# CITY OF ALBUQUERQUE

September 25, 2020

**Re: WAQ1 Delivery Station  
7300 Meridian PI NW  
Traffic Impact Study  
Dated September 2020 (HT#J1D002G1)**

I have reviewed and prepared comments for the initial Traffic Impact Study submittal for the WAQ1 Delivery Station development. Please resubmit the traffic study addressing the following.

Following is the proposed site development plan.

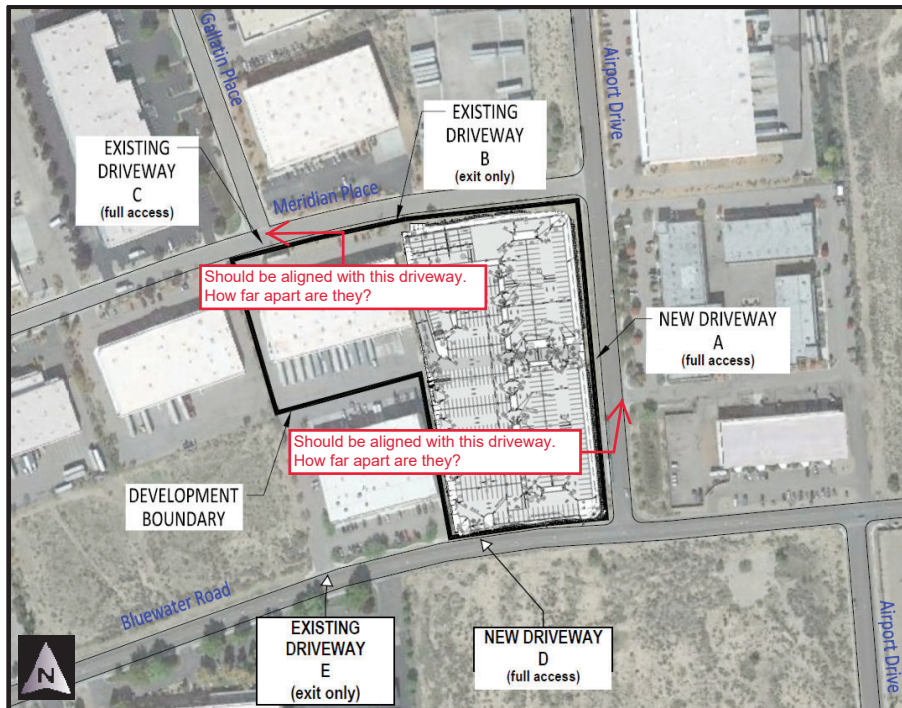
5. There is a second driveway to the property to the west of the development on Bluewater. Show the proposed driveway spacing and alignment with opposing driveways and intersections.
